23/00750/TEL56 – comments from Kirtlington Parish Council

Proposed 5G Telecommunications Installation at Station Road, Kirtlington

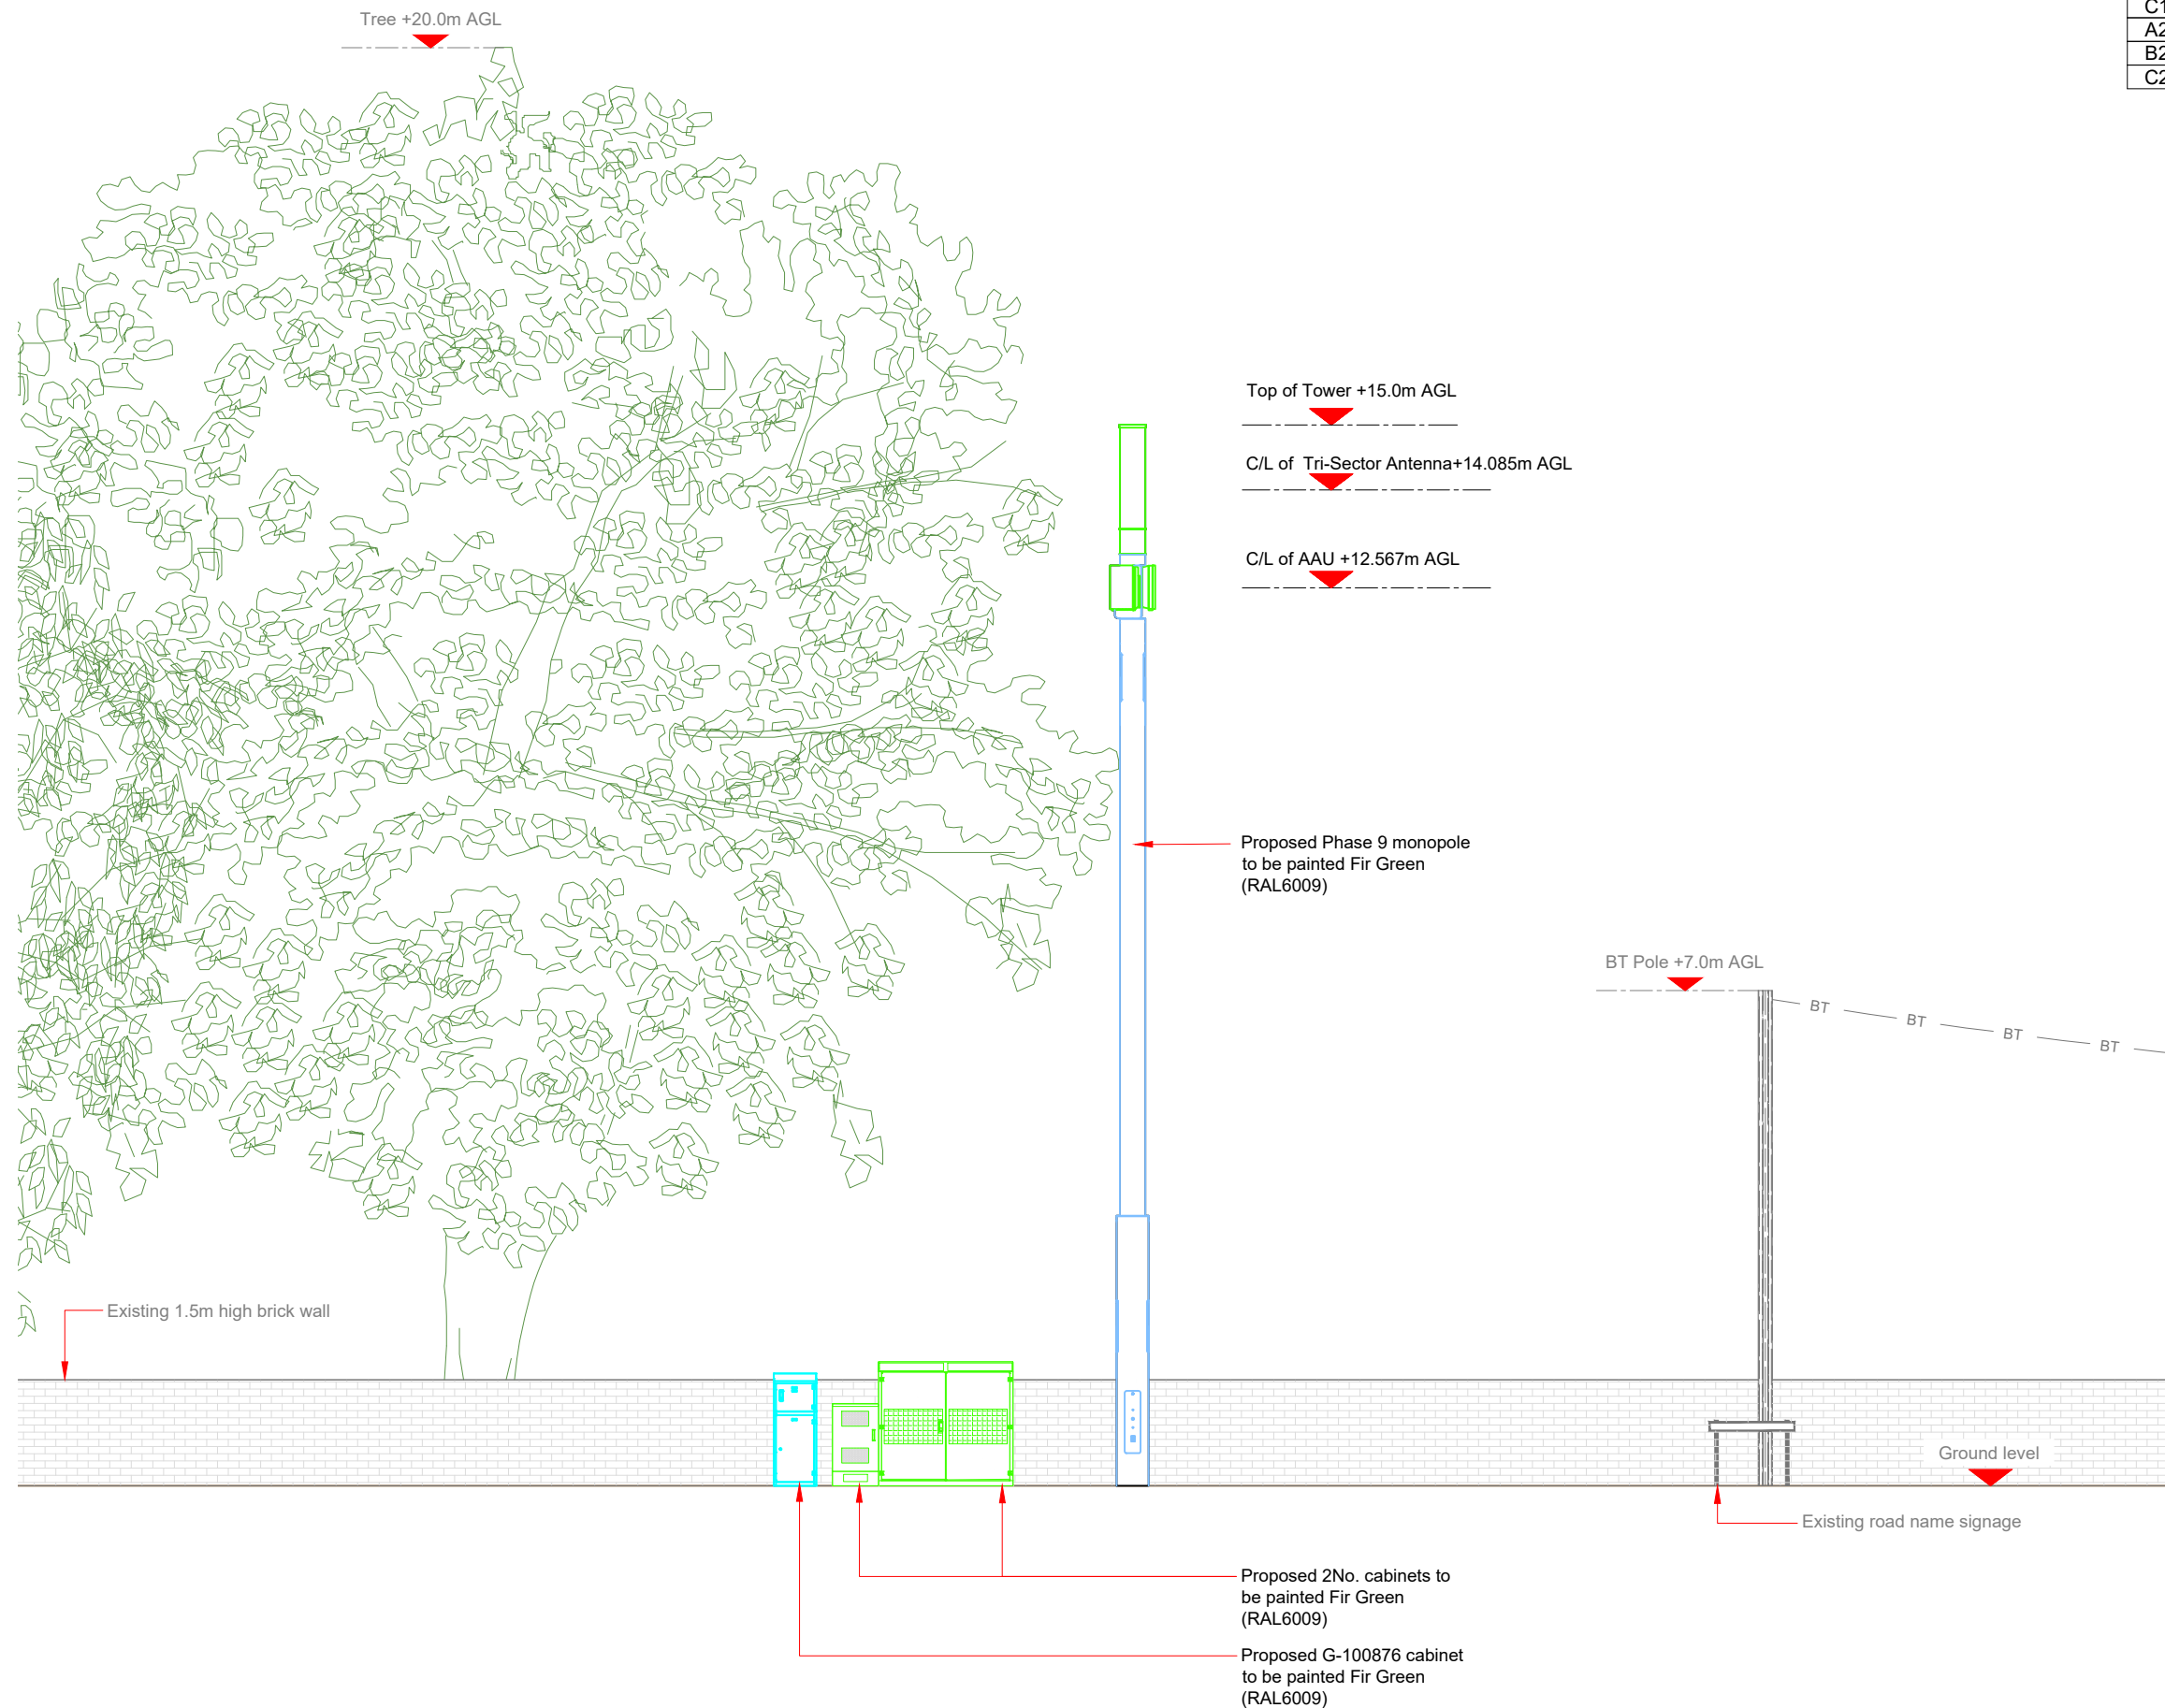
Kirtlington Parish Council would like to support the operator's roll out of the 5G network, but the location for this proposed 15m high monopole and its three associated cabinets is so ill-conceived in terms of its siting and appearance and the adverse effect that this development would have on the character and appearance of the village, that it feels compelled to strongly object to this application.

The site is thus very open to views from three directions, and the monopole and the associated cabinets would be visually prominent to the public using these roads, particularly when approached from the north. From this direction, the mast would be seen against a rural backdrop, comprising a wide panoramic view over the broad valley between Kirtlington and Bletchingdon, framed by trees, particularly a line of trees (including large conifer trees – which may be capable of blocking any signal) aligned north-south along the property boundary between Willow Tree Barn and Stoney Crest/South Farm. The mast and cabinets would also obscure a significant section of a traditional dry-stone wall and not an existing brick wall as stated on the Existing and Proposed Site Plans. These views and the open nature of the site make an important contribution to the wider setting of the Conservation Area and the landscape setting of this southern end of Kirtlington.

At 15m in height the proposed monopole would be significantly higher than the limited items of nearby street furniture, which includes a wooden BT pole at 7m high, a give-way sign and two low-level street name signs. In the absence of any other structures of comparable height in the immediate vicinity, the development, including the clutter of the associated cabinets, would be visually intrusive and introduce incongruous features within the street scene which would diminish the existing pleasant character and attractiveness of the Conservation Area.

If permission for the proposed mast were granted in the applicant's preferred location, then KPC requests that the cabinets are screened by placing them in a stone walled enclosure, built parallel to the existing retained stone wall. Such mitigation would be supportive of Policy PD5: Building and Site Design of the Mid-Cherwell Neighbourhood Plan. In addition, this verge, up to a few years ago, was the location of a fine mature False Acacia, which unfortunately died, therefore it is requested that a native species tree, of ultimately similar stature, should be replanted in its place, to help mitigate the visual intrusion of the mast on this sensitive location in the village.
